**Objection to the**  
**Young to Wellington Gas Pipeline**  
**ERM Power Pty Ltd**

23 June 2010

**Roland Hill**

Figure 2. YWP Route – October 2009.

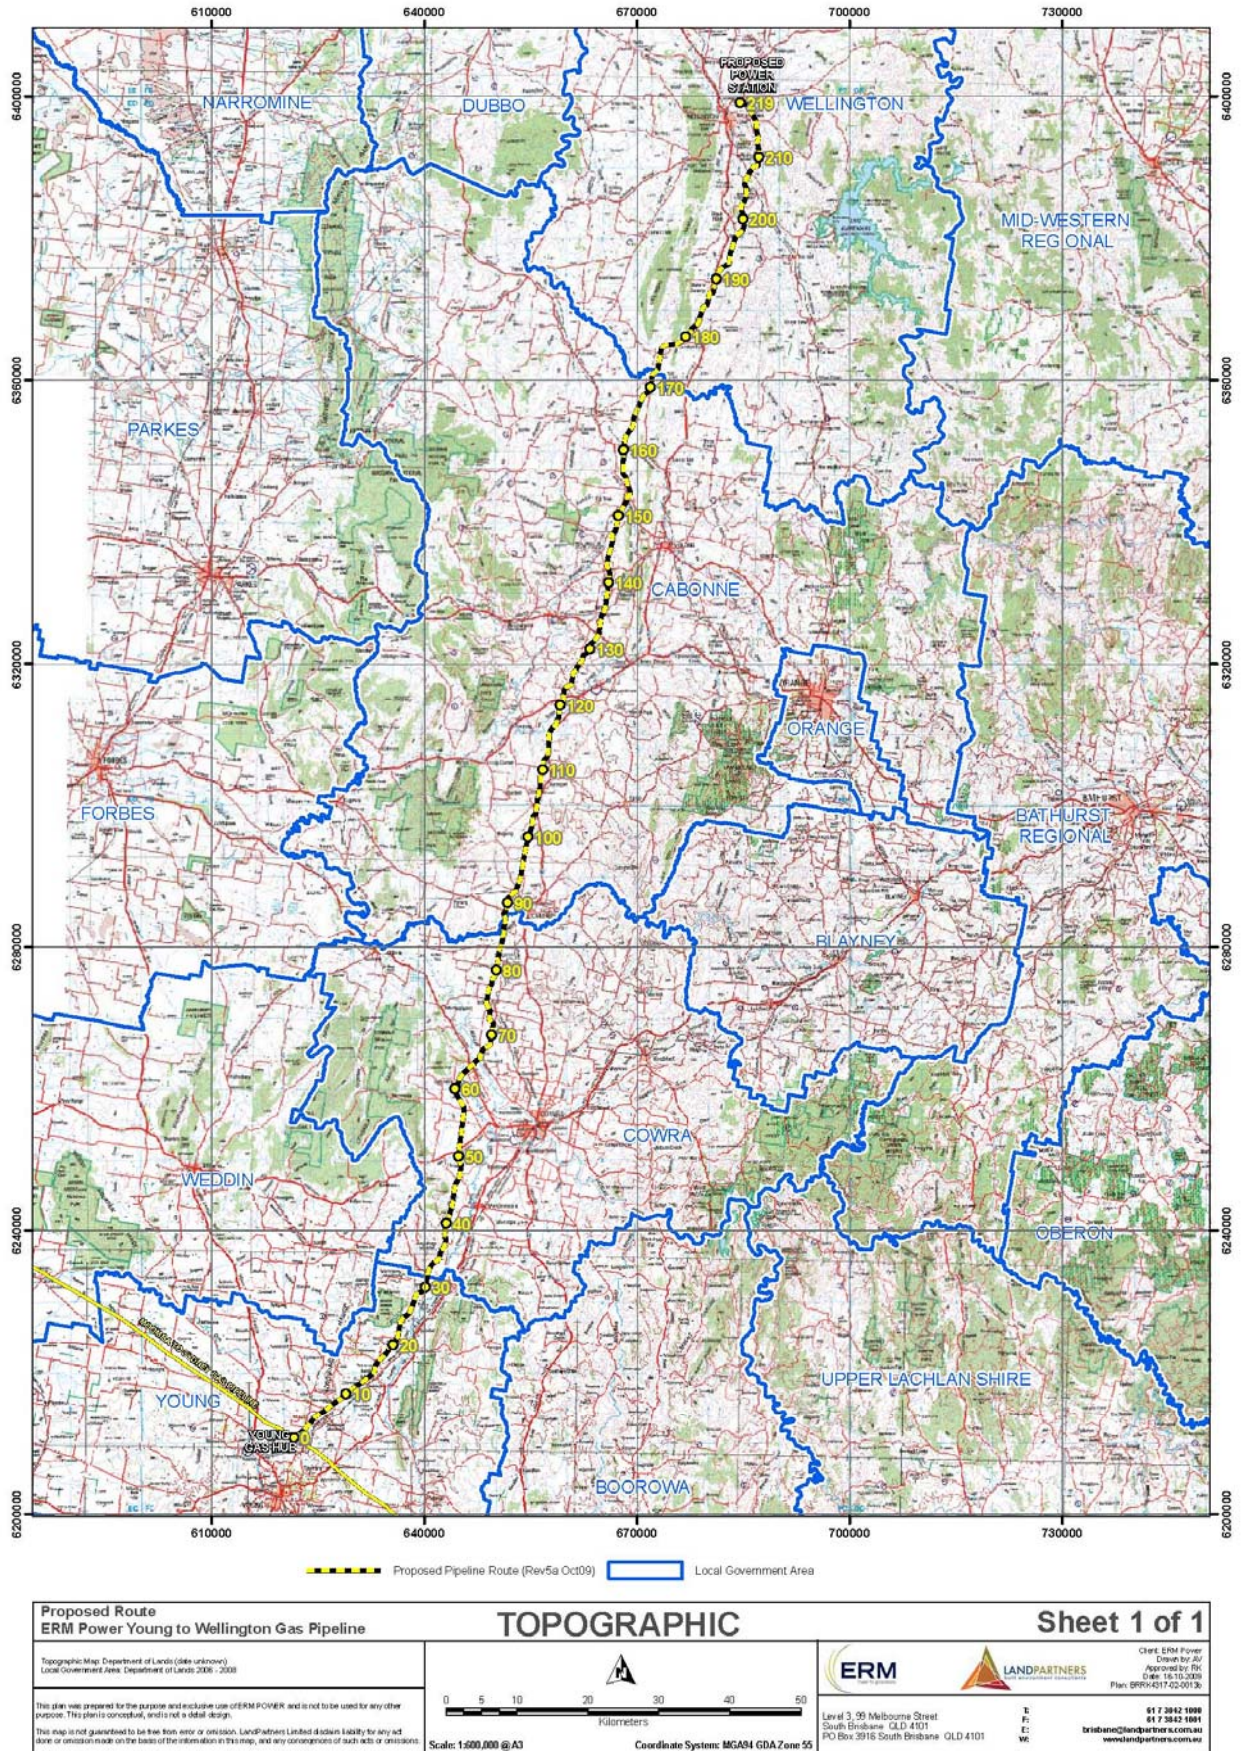
The proposed route has preferred private land and therefore maximises the number of adversely affected landholders. This is despite alternative routes being available (Figure 1) utilising the extensive network of north-south road reserves throughout the area. Utilising these paths has a number of advantages:

- These are pre-existing cleared paths in the order of 25m wide.
- Use of existing paths dispenses with the need to clear and grade new paths through private land.
- The pipe is laid along one margin of the easement, this means that most construction traffic would be utilising pre-existing dirt roads, and that the trench would not be located on the formed road.
- The pipeline could be monitored without intrusion onto private lands.
- Individual landholders would not be burdened with the environmental problems associated with the abandoned and corroding infrastructure.
- Individual landholders do not have the experience or knowledge to ensure their rights, and the rights of future generations on their land, are preserved, particularly once the easements have been dropped.

In the area around Rosehill alone, 6.6km (the limit of my image) of pipe could utilise the existing infrastructure corridor, minimising the environmental impact and the impact on landholders. This can be achieved without any dwellings being located within the safety distance determined by ERM. I believe the road to the south of my image extends this by another 2.3km. This can be achieved just 400m from the route proposed by ERM. Note that this alternative does not resolve post-abandonment issues, but lessens the burden on individual landholders.

A 940m long rehabilitation and fauna route has already been established across Rosehill. The proposed pipeline route cuts this and will prevent the completion of revegetation with native tree species along this route. It will also prevent us from planting 7 other paddock corners and 700m of fence line with trees as we have planned. This will have a significant impact on our livestock, native fauna and property management.

As well as preventing revegetation, the route as proposed will remove 8 mature trees from our property and cut through fossiliferous limestone outcrops that form a habitat for lizards on the property.

The proposed pipe route crosses a NE-SW trending fault with an estimated 1km sinistral offset (as seen in limestone ridges). The fault is indicated on air photos by a straightening of the, otherwise meandering, creek, providing for a 250m sinistral offset in the original creek path. There has either been movement along the creek since the current creek path was established, or the creek has preferentially established along the fault. The proposed pipe crosses the fault from unconsolidated soil on the SE side, directly into solid limestone on the NW side. This will ensure that **any further movement along this fault will shear the pipe causing a catastrophic failure.**
